A/45/19/PL - Application meeting following Conservation Officer and Conservation Area Advisory Committee (CAAC) comments

Engineers Comments Regarding Surface Water Drainage

APPLICATION A/45/19/PL

Description of Works: Demolition of existing buildings (car show room, workshops and Phares Courtledge) and erection of 19 dwellings, a convenience store, a community building, public toilets and associated car parking and landscaping - This application affects the character and appearance of the Angmering Conservation Area.

| Date  | March 2019 | Drawing No. | 2018-D1620-PL400 | Rev        |    |          |    |

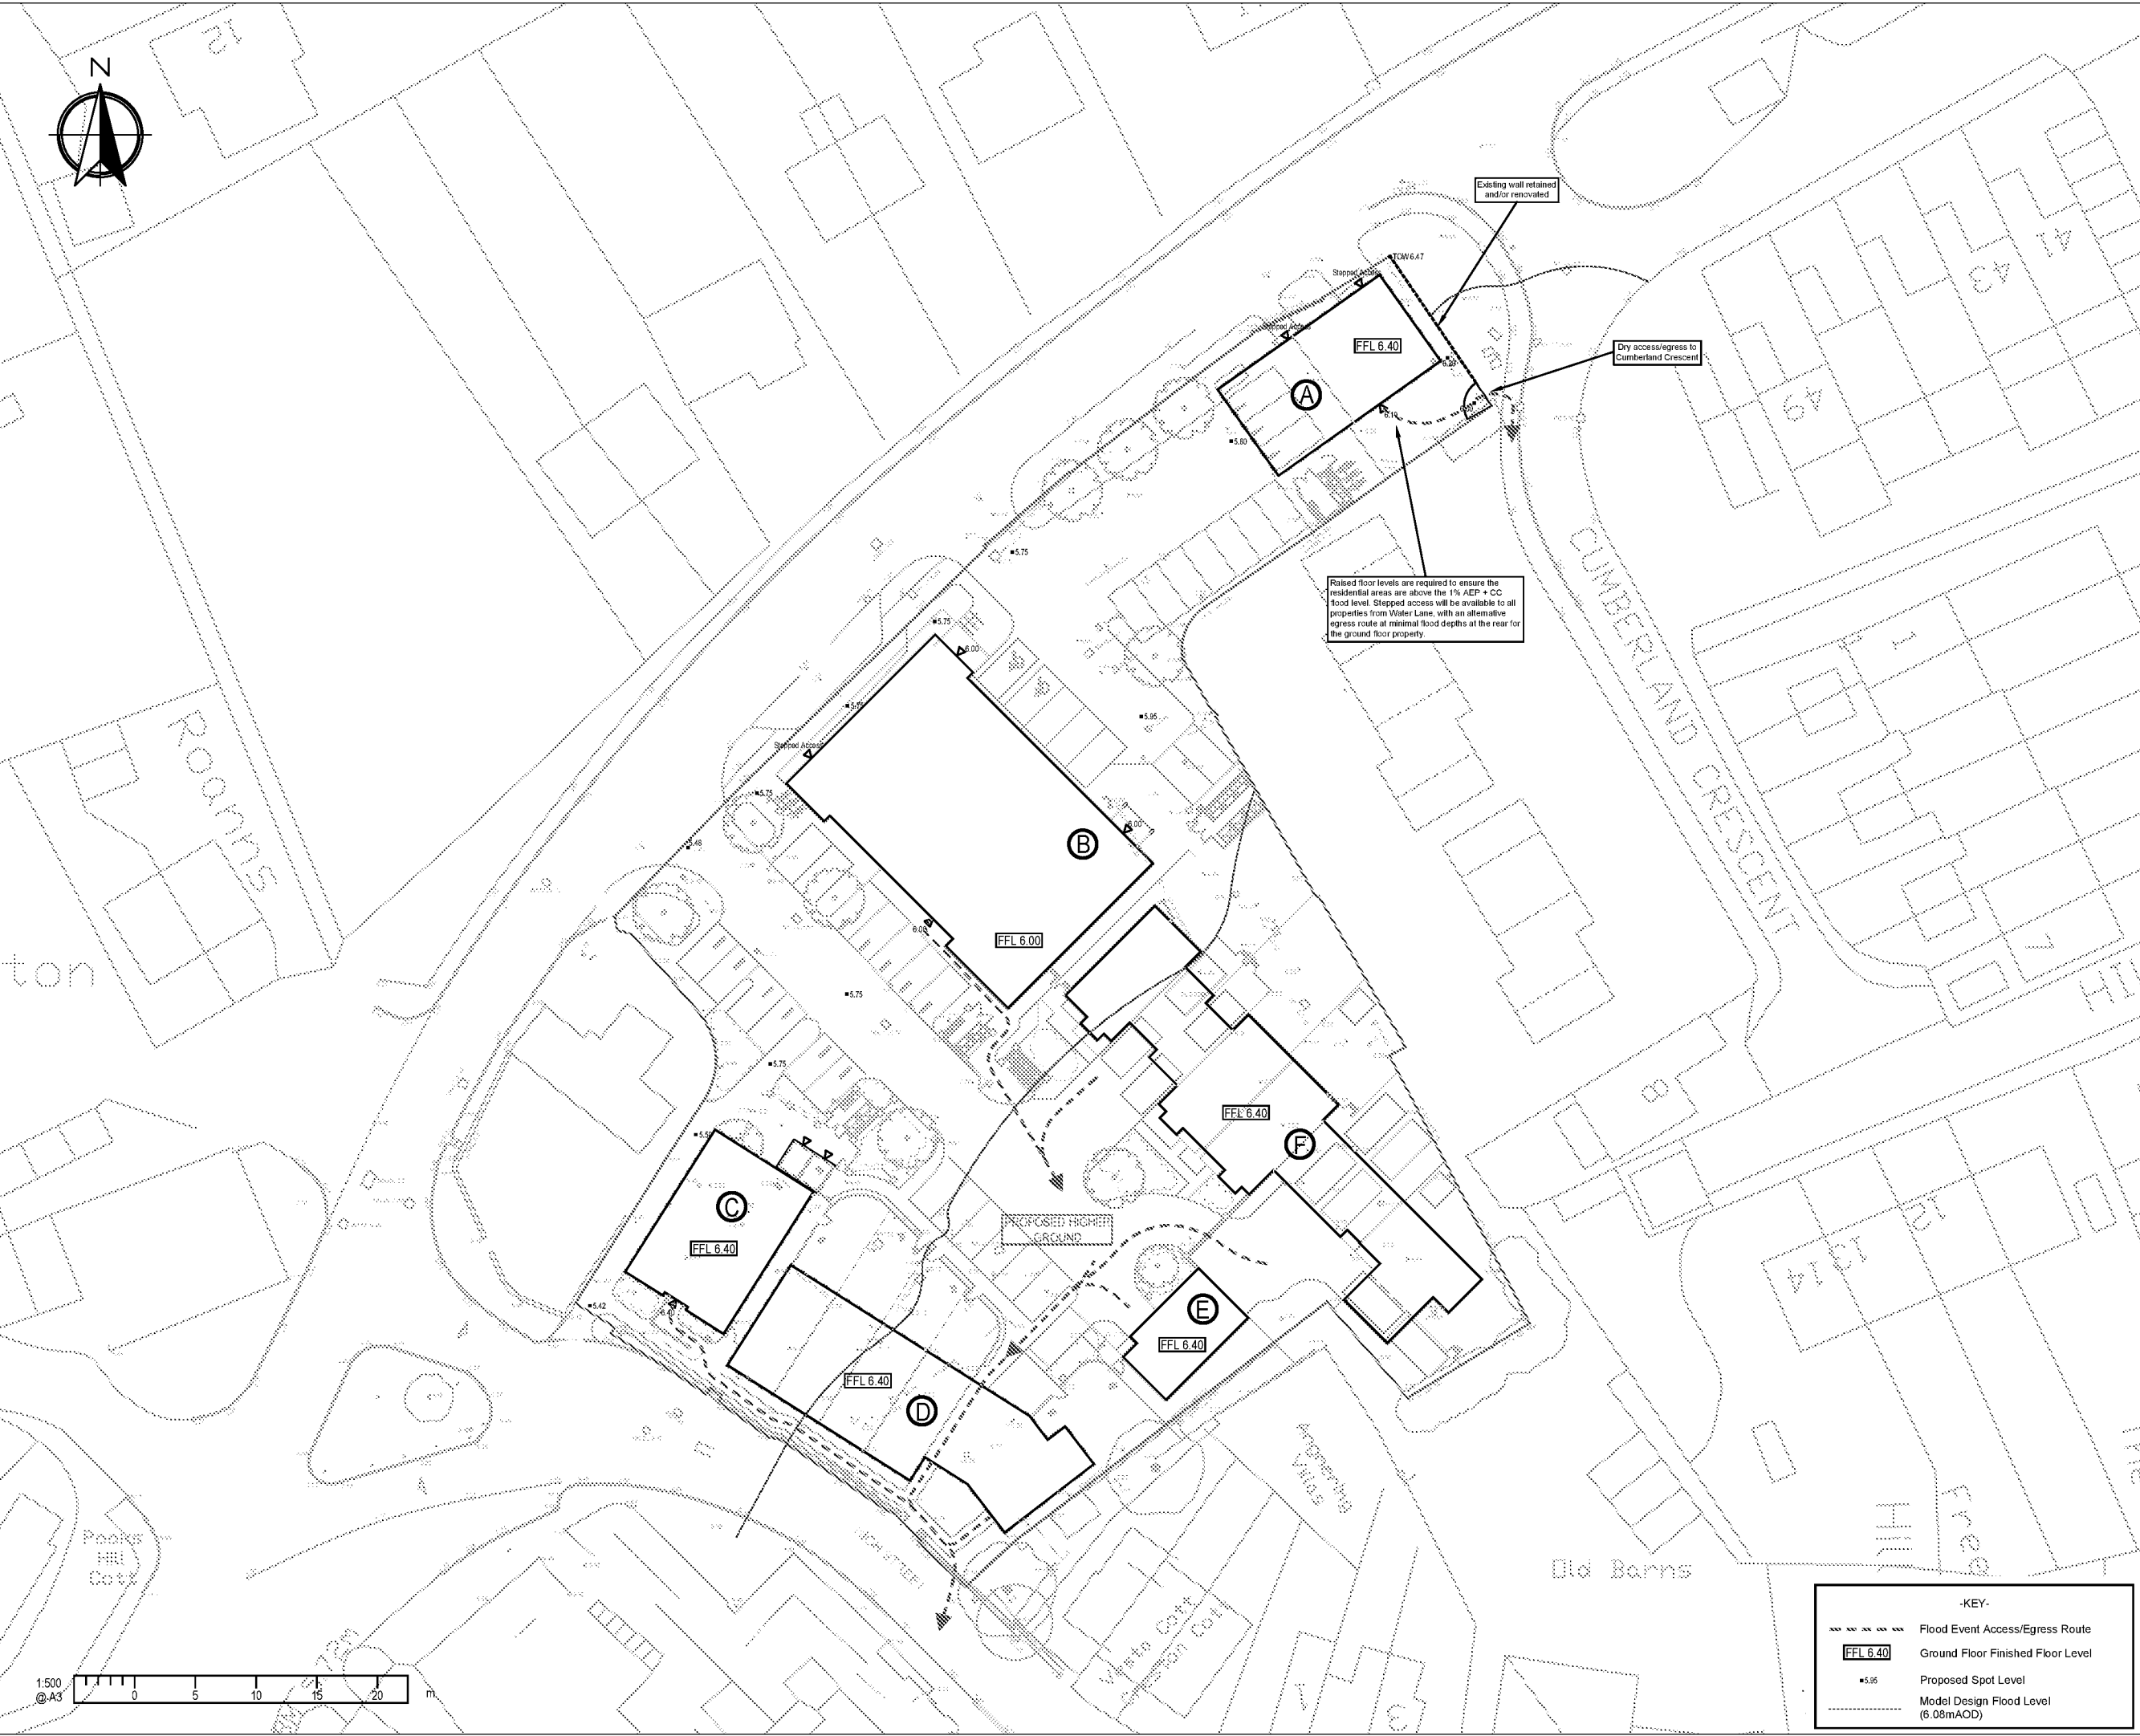
The site is also at risk of surface water flooding. Proposed attenuation or infiltrating structures must be located outside of the predicted fluvial and pluvial extents.

The submitted FRA details that some of the existing drainage arrangement will be utilised. Given the high risk of flooding in the area we would be looking to obtain improvement from the proposals, in line with WSCC policy we require proposed discharge rates to be as close to greenfield QBar as possible. Any proposals to alter or provide additional connections to the culverted main river would require a flood risk activity permit from the Environment Agency.

It is not clear from the detail submitted if the attenuated volume can be contained on site outside of the predicted flood extents. I.e. it has not been demonstrated that the proposals will not increase flood risk and the development can be adequately drained. A layout plan of the proposed surface water drainage scheme needs to be submitted, with further refined calculations. This information needs to be submitted before determination of the application. **Therefore, I currently object to the proposal.** Once further detail has been supplied by the applicant please re-consult.

"Development shall not commence, other than works of site survey and investigation, until full details of the proposed surface water drainage scheme have been submitted to and approved in writing by the Local Planning Authority. The design should follow the hierarchy of preference for different types of surface water drainage disposal systems as set out in Approved Document H of the Building Regulations, and the recommendations of the SuDS Manual produced by CIRIA. Winter groundwater monitoring to establish highest annual ground water levels and winter Percolation testing to BRE 365, or similar approved, will be required to support the design of any infiltration drainage. No building / No part of the extended building shall be occupied until the complete surface water drainage system serving the property has been implemented in accordance with the agreed details and the details so agreed shall be maintained in good working order in perpetuity."

"The development shall not proceed until details have been submitted to and approved in writing by the Local Planning Authority for any proposals: to discharge flows to watercourses; or for the culverting, diversion, infilling or obstruction of any watercourse on or adjacent to the site. Any discharge to a watercourse must be at a rate no
